RE: Iron Mountain Short Plat (SP-06-129)

The Kittitas County Community Development Services Department has determined that the Iron Mountain Short Plat is a complete application and hereby grants **conditional** preliminary approval subject to the following conditions:

SHEET 1 OF 3

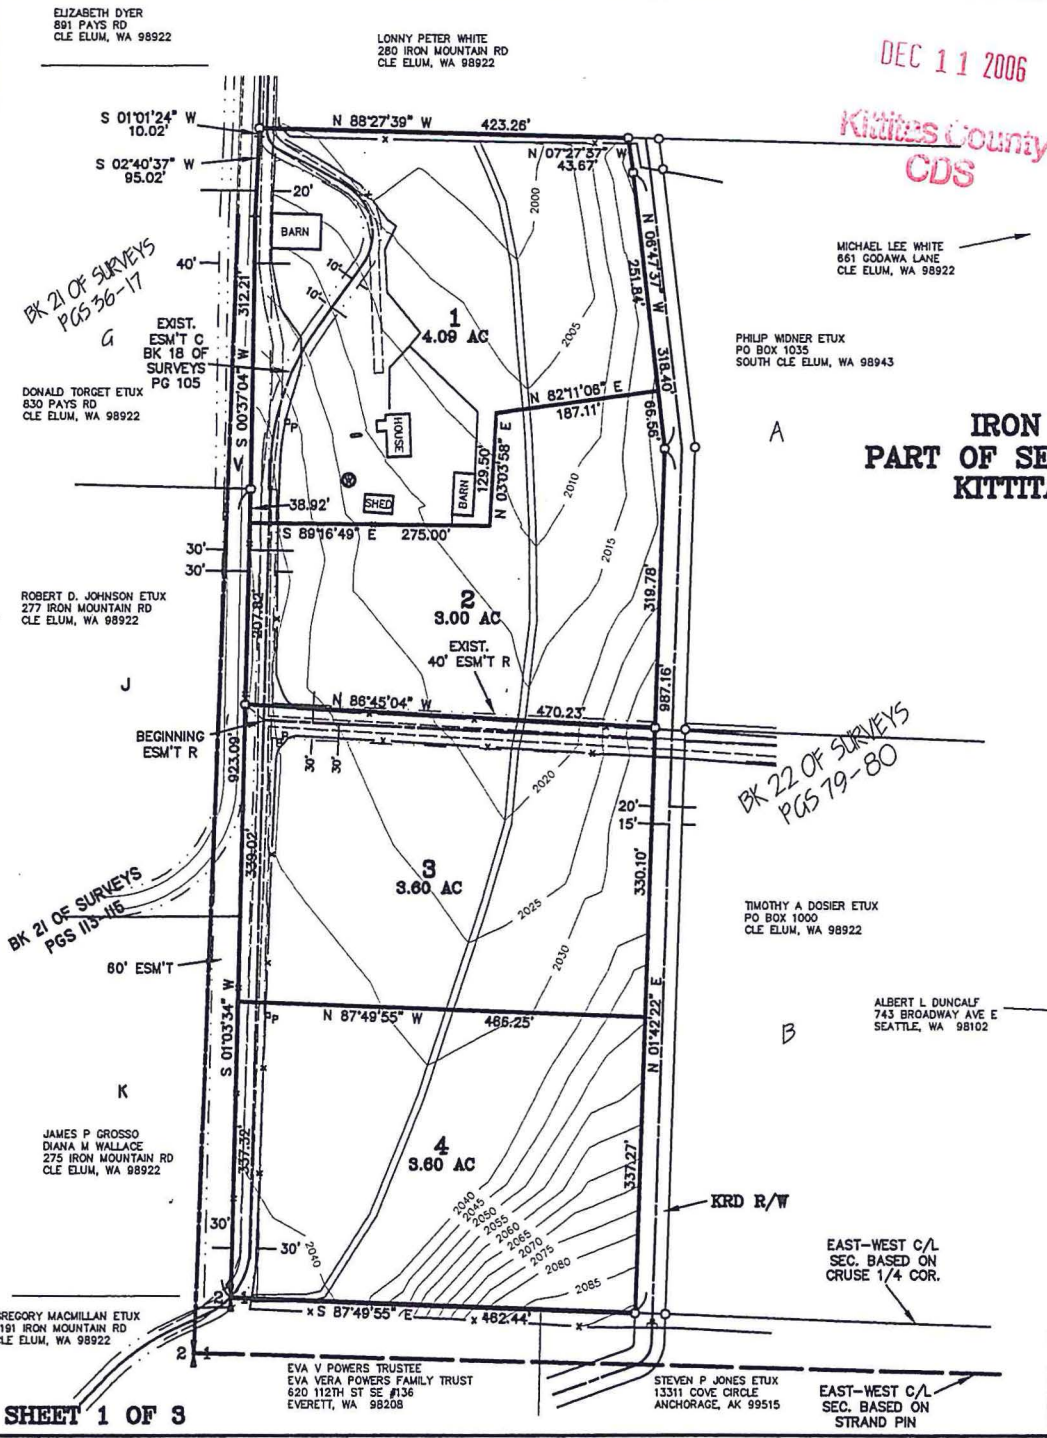
1. Both sheets shall reflect the short plat number SP-06-129.
2. All future development must comply with International Fire Code (IFC) and appendices.
3. All Kittitas County road standards must be met. Attached you will find comments from Kittitas County Public Works. Please contact Christina Wollman at 962-7051 regarding all road standards and access questions.
4. Attached you will find comments from Kittitas County Environmental Health. Please see those documents for required plat notes and information on issues needing completion before final approval of this short plat.
5. Submittal of a Certificate of Title (Title Report) with the final short plat mylar.
